**Date:** 22<sup>nd</sup> November 2023  
**Heritage Advice Ref:** 23/03006/LB1

**Request for Heritage Advice at The Old Manor, Church Lane, Tingewick, Buckinghamshire, MK18 4RB**

## **The Old Manor, Church Lane, Tingewick**

PROPOSED FIRST FLOOR PLAN 1:50

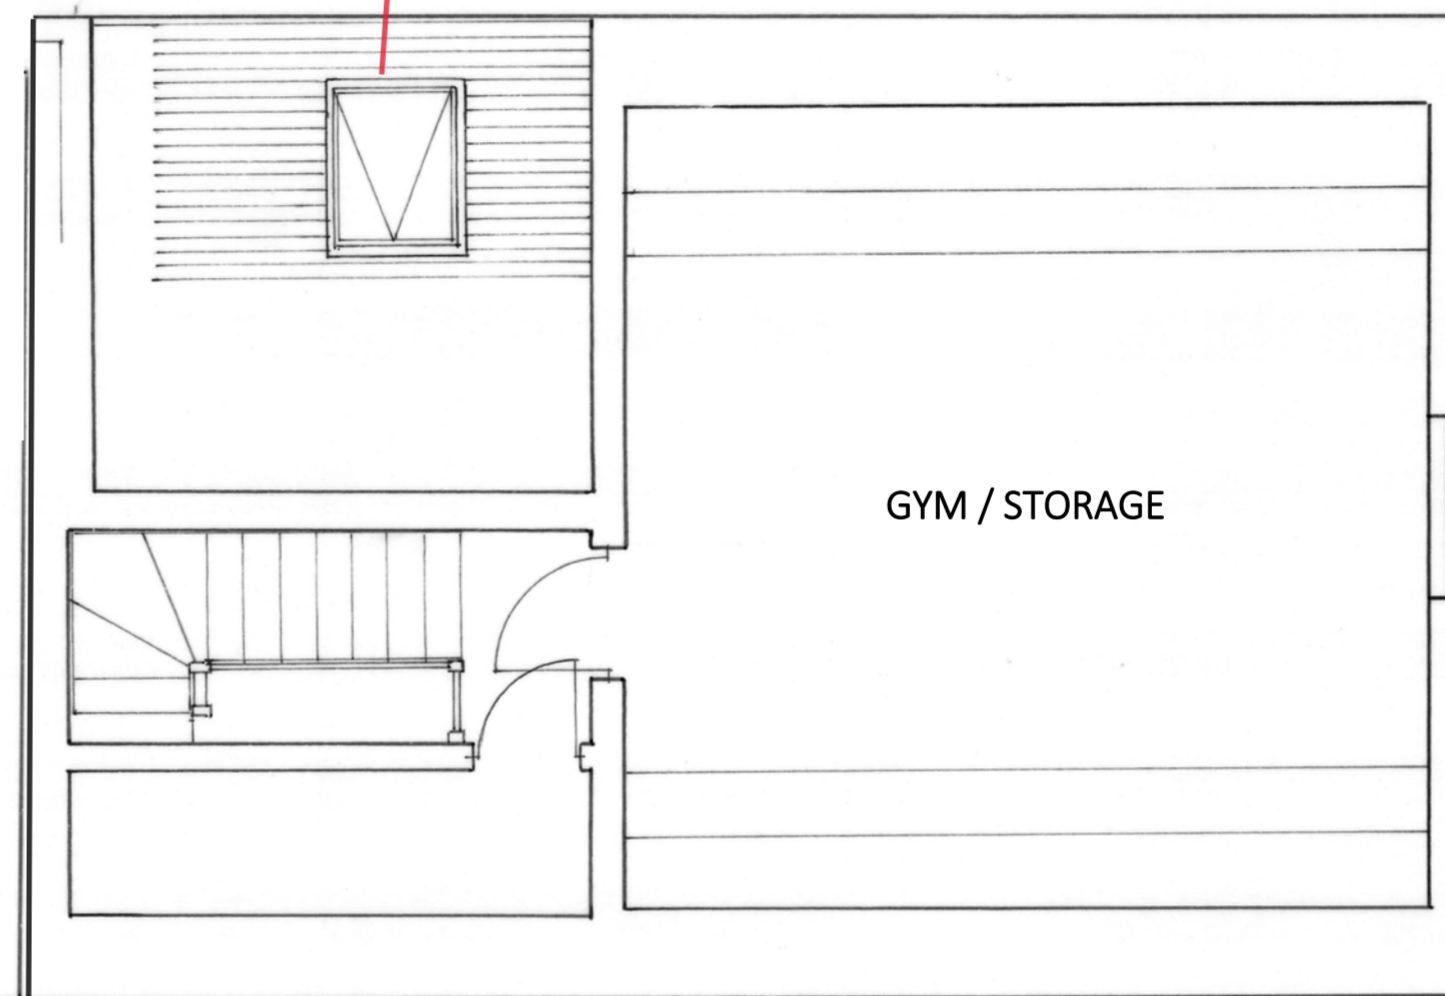
The proposed new joinery would not require listed building consent provided it is carefully fitted around the exposed timber beams. Altering the timber beams to fit new joinery would require listed building consent and would be discouraged as the intervention and loss of historic fabric would not be justified only to provide built-in storage units.

Uneven historic floors/floorboards are resisted being levelled down. They form part of the character of the building and would involve loss of historic fabric which would represent a harm to the listed building. Any harm to the significance of a listed building needs to be robustly justified or be outweighed by public benefit. In this instance there would be no public benefit and the comfort of the current owners/occupiers of the building does not justify loss of original fabric.

However, raising up the floor level, as described in planning pre-app 23/02956/WIGD would be acceptable providing it is reversible and the skirting boards are not historic. The platform should be aligned with either the window or doorway, it is currently shown to finish below the window. If the floorboards below the carpet are historic, the new platform would need to be carefully detailed so there is no harm to them and it is reversible. Due to the potential of harming/scarring historic floor finishes and structure, listed building consent would be required to demonstrate the platform is reversible.

Similarly to above, if the new opening would result in loss of historic fabric then sufficient justification will need to be provided to outweigh the harm. An application for listed building consent would need to establish whether the partition is original or a later addition. If it is found that the partition is not historic, and this can be demonstrated within an application, then the new opening would be accepted. Another consideration in creating new openings between rooms is whether the plan form of the building (the individual rooms and their relationship to each other) is still readable. As the partition is not proposed to be fully removed and the existing doorways are retained, it is felt the plan form of the different rooms is still legible.

PROPOSED GROUND FLOOR PLAN 1:50

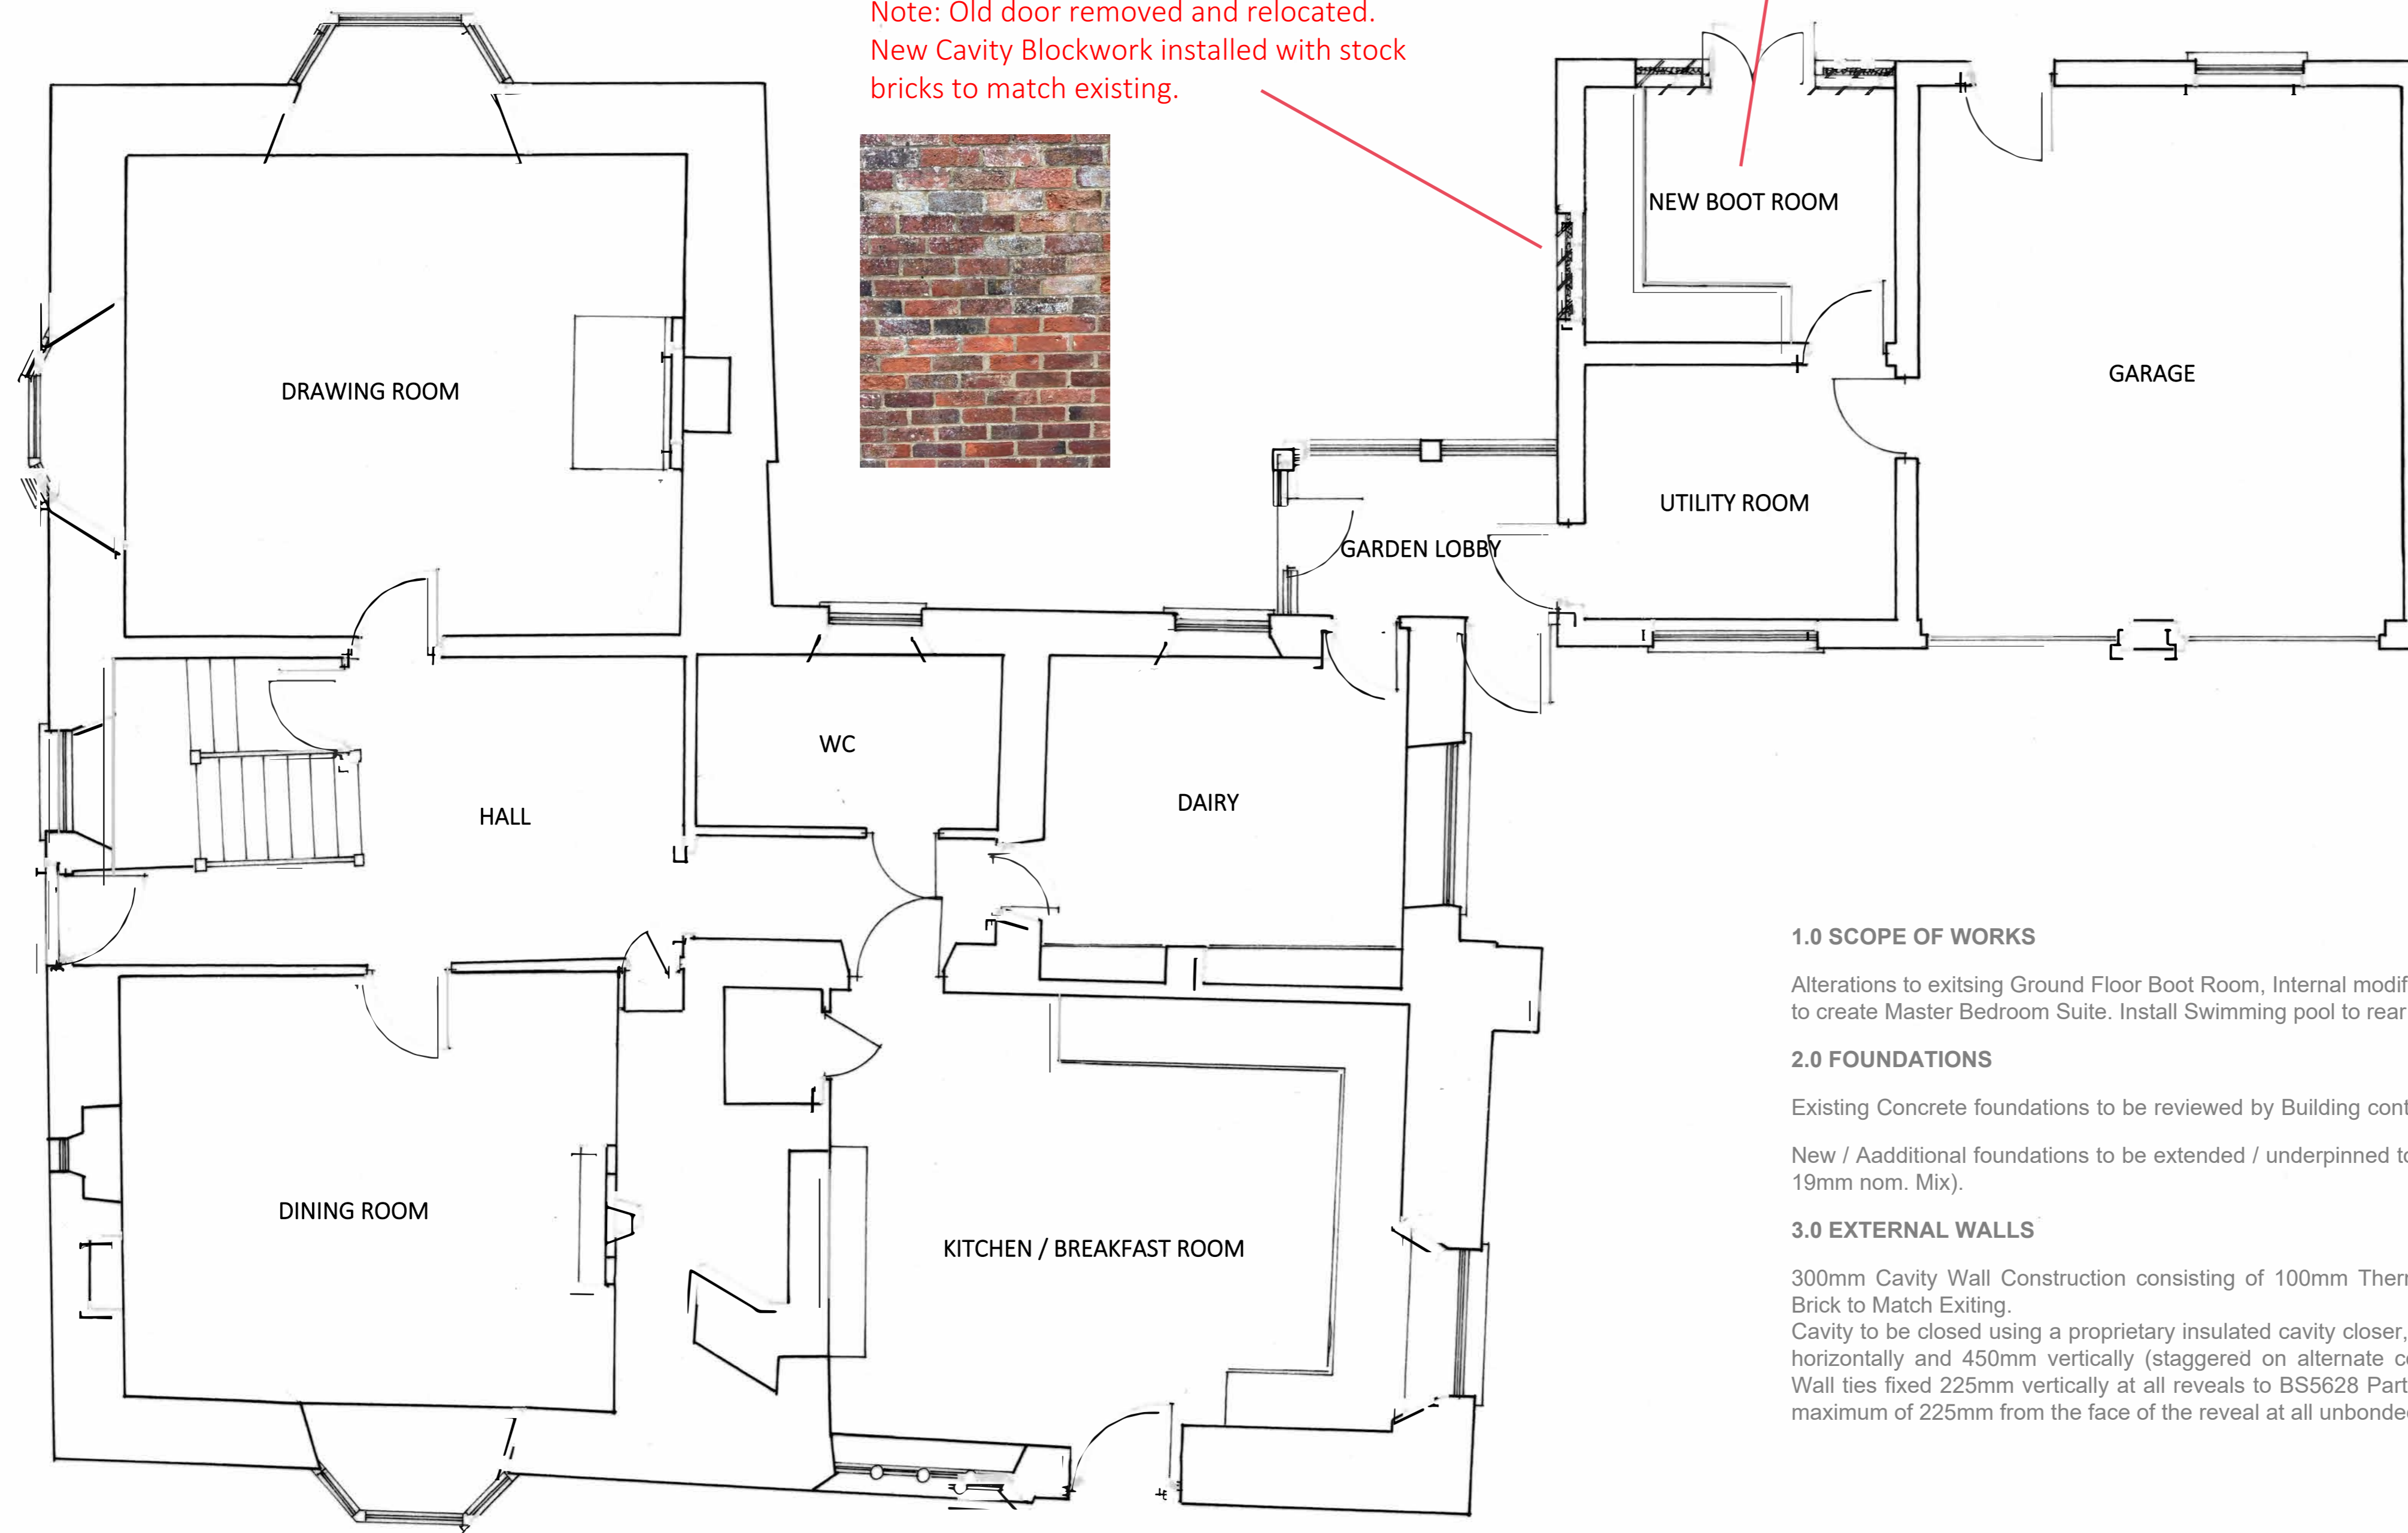
The double garage is a modern addition to the property and the proposed alterations to the external door and rooflight would not raise concern. The rooflight would need to be of conservation style and fitted flush to the roof slope. The new bricks and mortar used for infilling would have to match exactly the size and colour of the existing to minimise the visual scarring of the new brickwork infill. The internal joinery shown in the precedence images would not impact historic internal features and would not require listed building consent.

PROPOSED SWIMMING POOL LOCATIONS 1:50

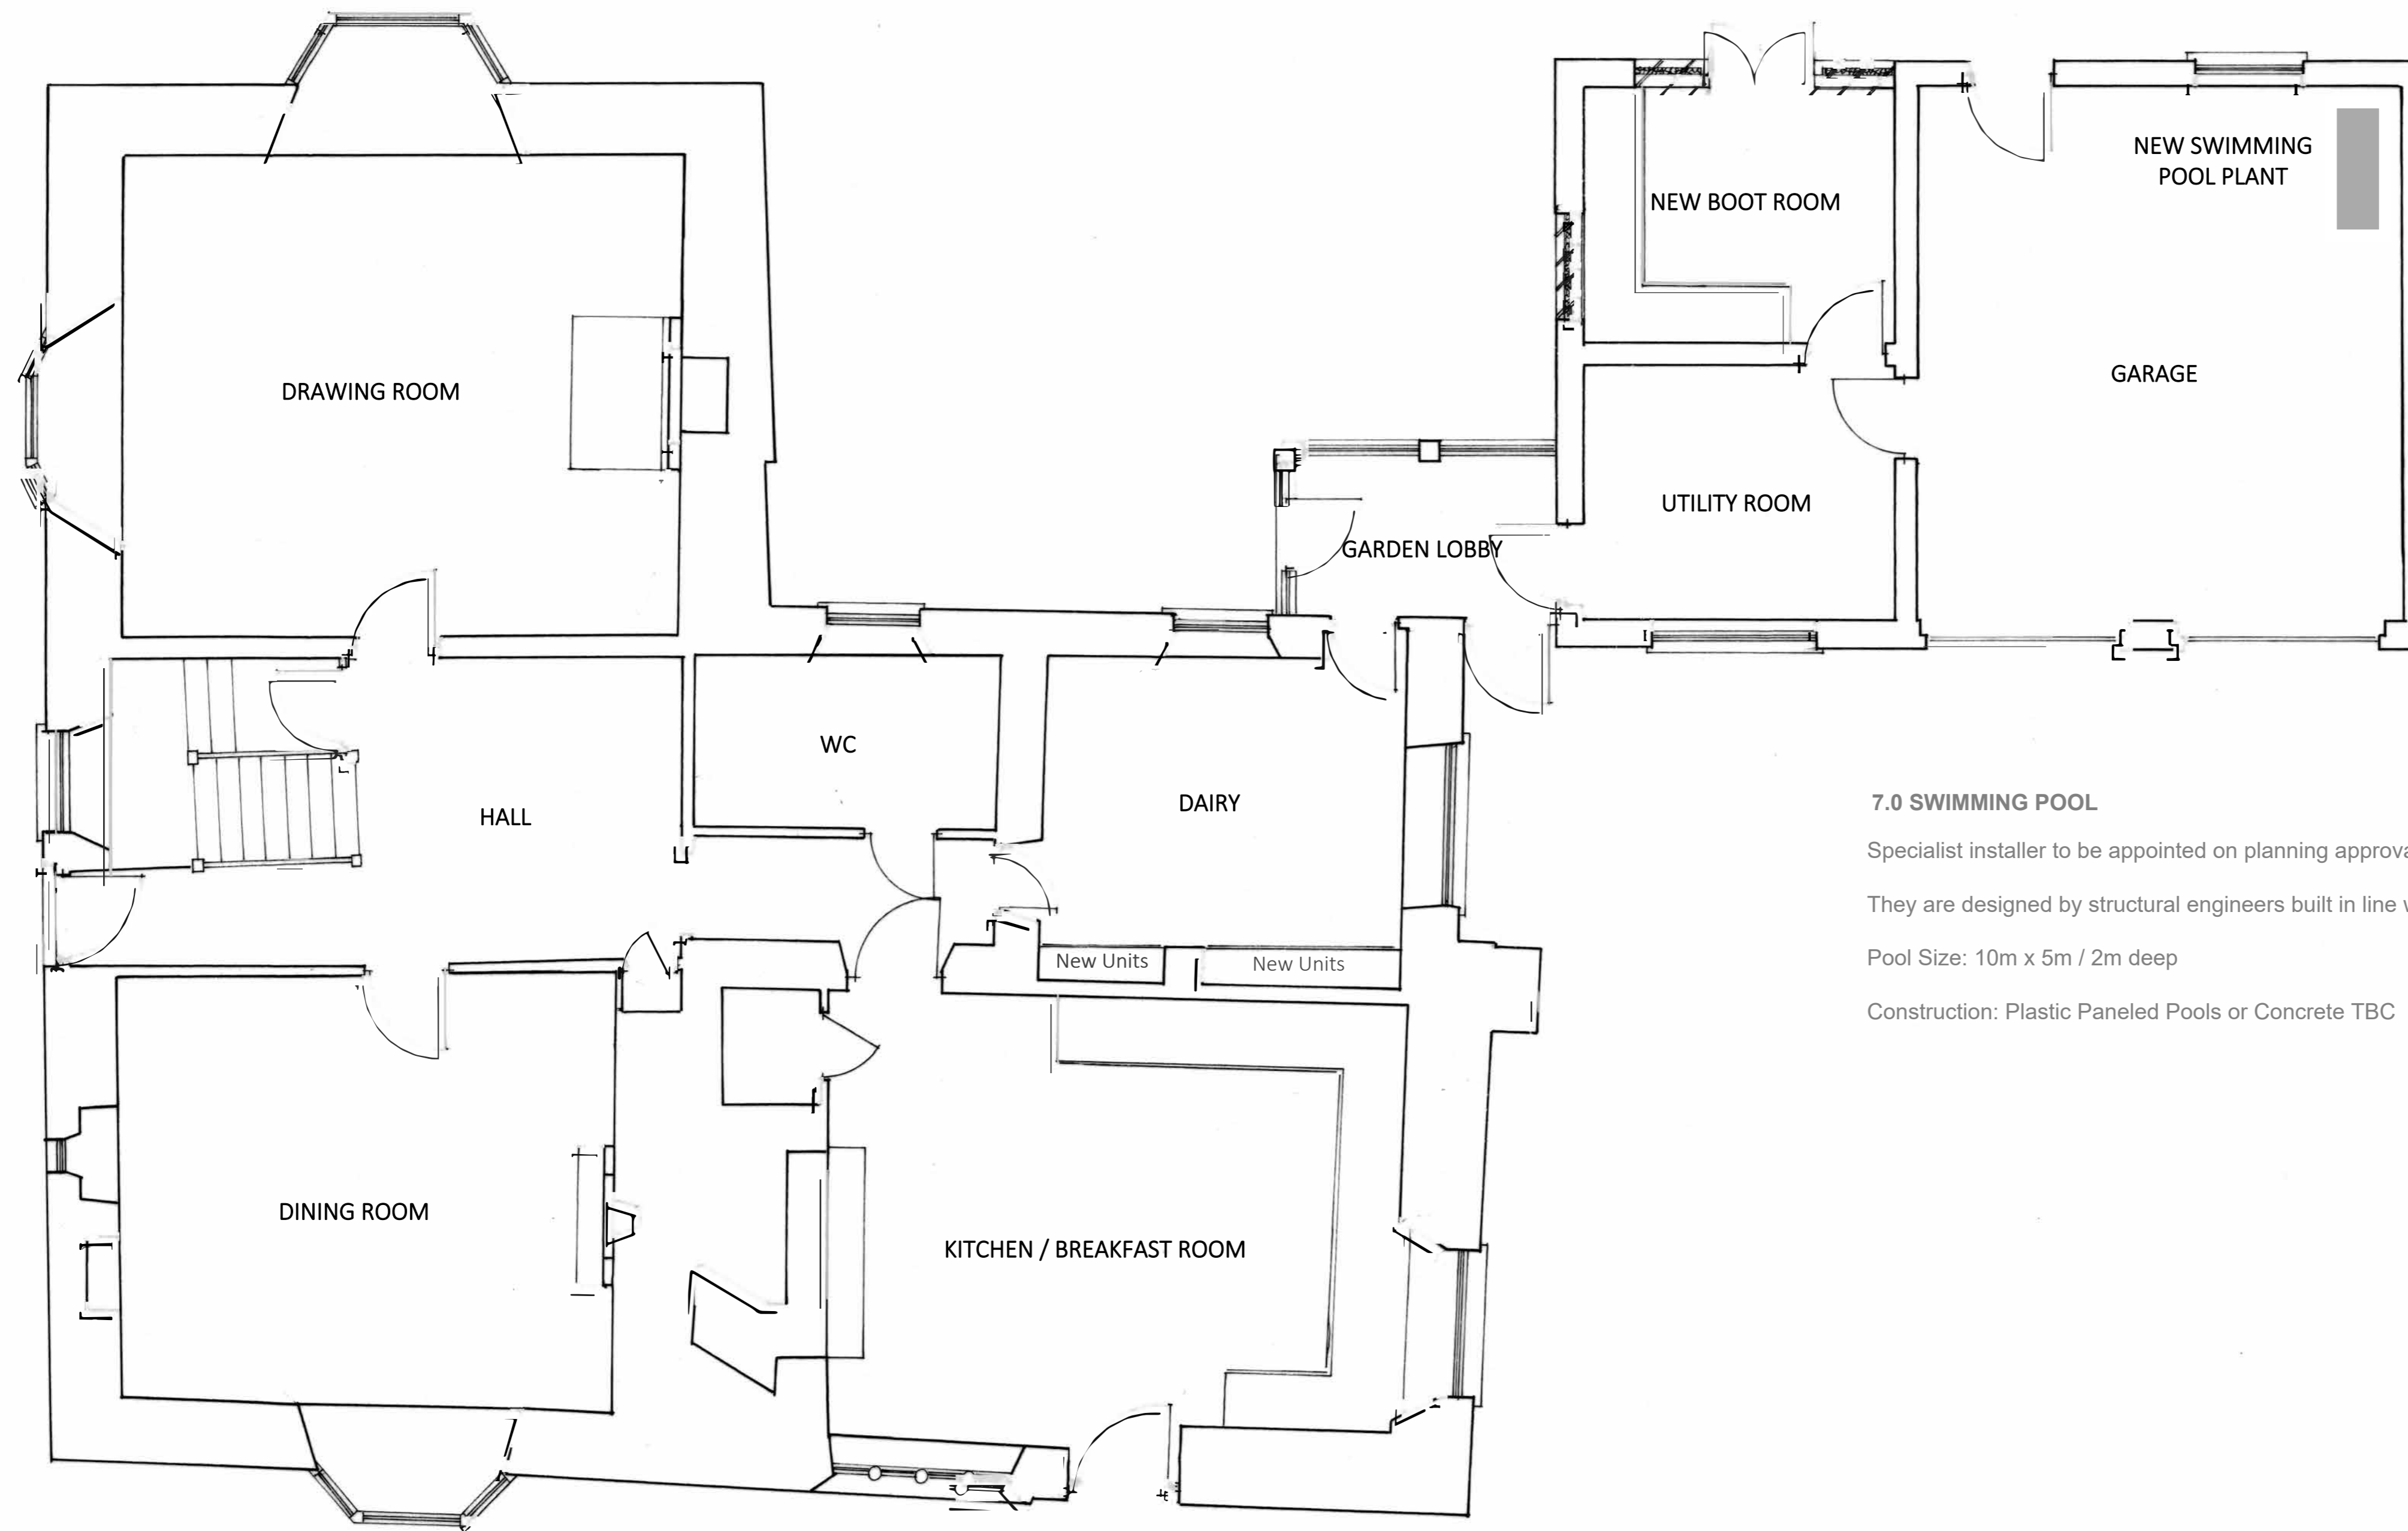
The location of the proposed swimming pool is felt to be too close to the listed house and potential archaeology being close to the neighbouring churchyard. The size of the swimming, particularly, in this location, is also felt to be too large as it appears to be of a similar footprint to half of the host dwelling. Alternative locations within the grounds further away from the house and churchyard should be investigated. Careful consideration will also need to be given to any potential archaeology that may be disturbed and the loss of trees should be minimised or mitigated.

Concern is also raised to locating the swimming pool plant equipment within the cellar of the house. The 15<sup>th</sup>/16<sup>th</sup> century window on the front elevation may be evidence of an earlier building on this site that the window was salvaged from and the cellar may be a remnant of an earlier structure. Any new connections through the cellar walls would be resisted as this would result in loss of historic fabric. Maintenance issues with the plant equipment would also have the potential for water damage to the foundations of the historic structure. Similarly, excavations around the cellar to facilitate installing the connections to plant equipment may destabilise the foundations of the building/cellar. If an alternative location for the swimming pool is found acceptable it would be less harmful to the historic fabric of the building to locate the swimming pool plant equipment within a new purpose built structure or within the existing double garage extension. The placement of any new structure would have to be carefully considered to not negatively impact the setting of the surrounding heritage assets.
